## **Thanet Extension Offshore Wind Farm**

Appendix 35, Annex B to Deadline 1 Submission:

### **Log of Changes to the Draft Development Consent Order**

Date: January 2019

Onshore Street Work Plans - Sheet 1 of 2

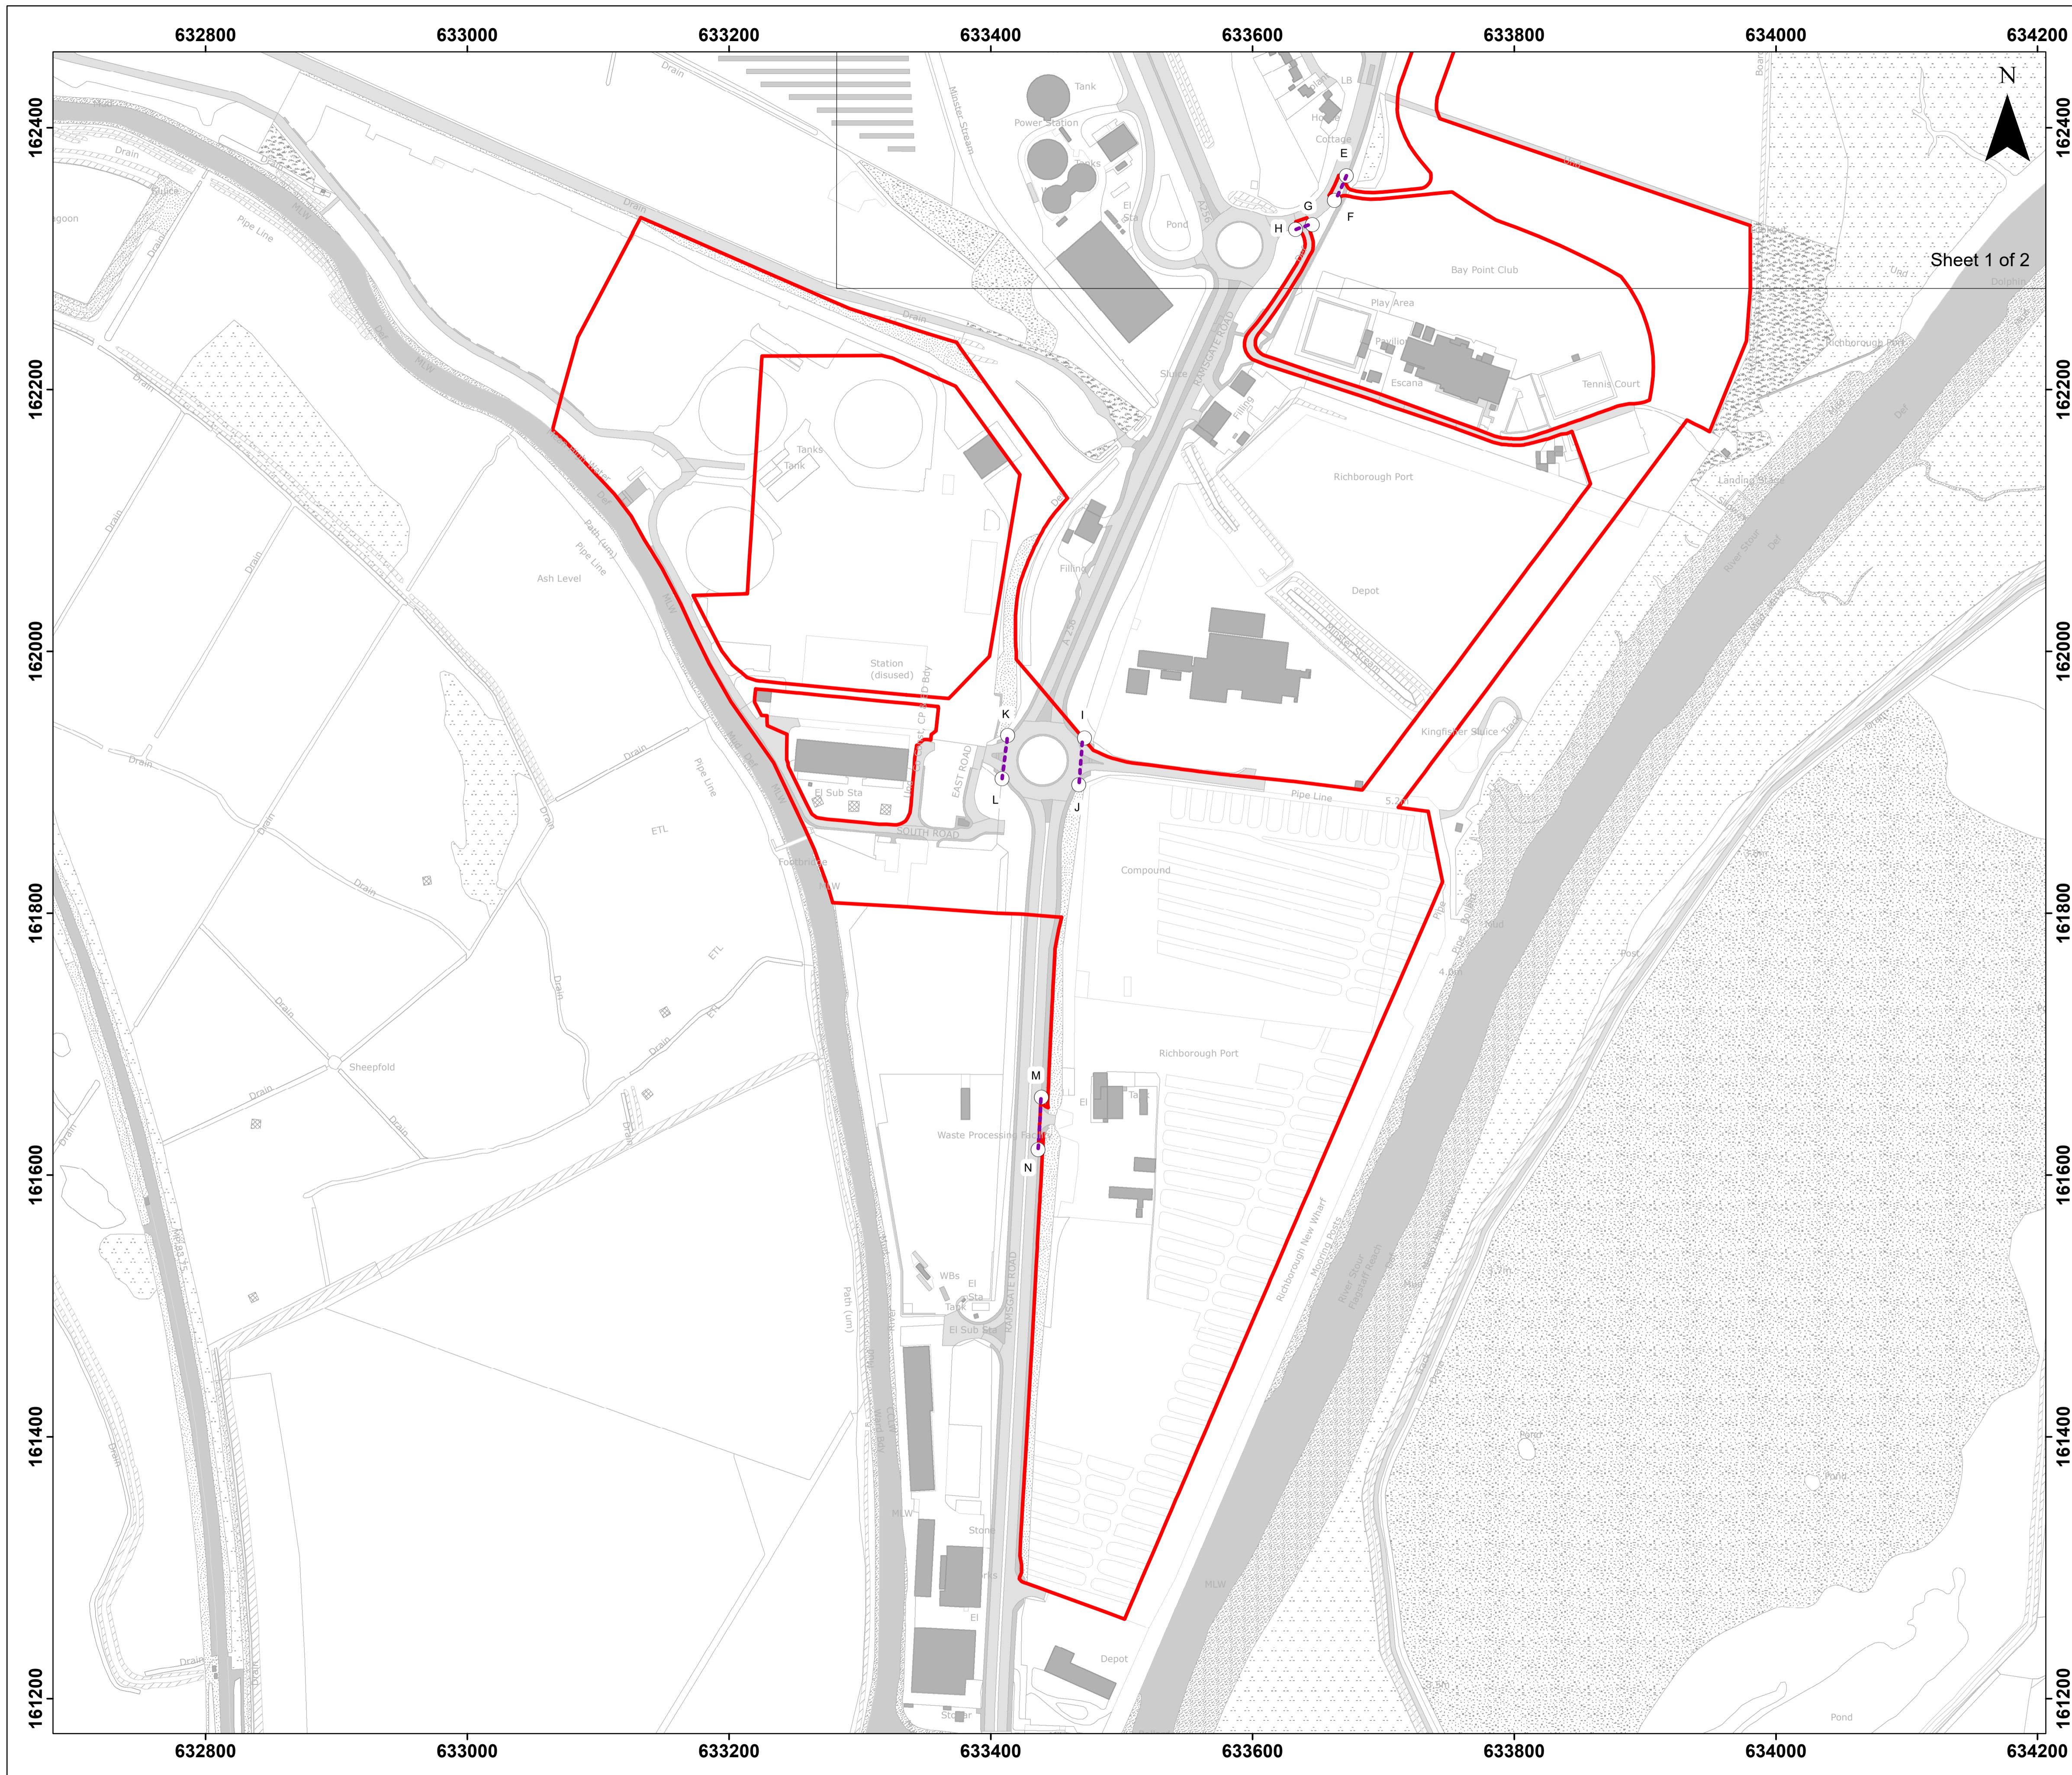
Ref	DCO Ref.	Rationale for change	Change made	DCO Version
1.	Schedule 2	In their Section 51 advice issued to the Applicant, the Planning Inspectorate noted that:  “In relation to the dDCO Schedule 2, the dDCO refers to the works plans. This should be the onshore street works plans.”	The wording has been amended throughout Schedule 2, for example –  <i>SANDWICH ROAD at reference point A-B on the <u>onshore street</u> works plan</i>	2
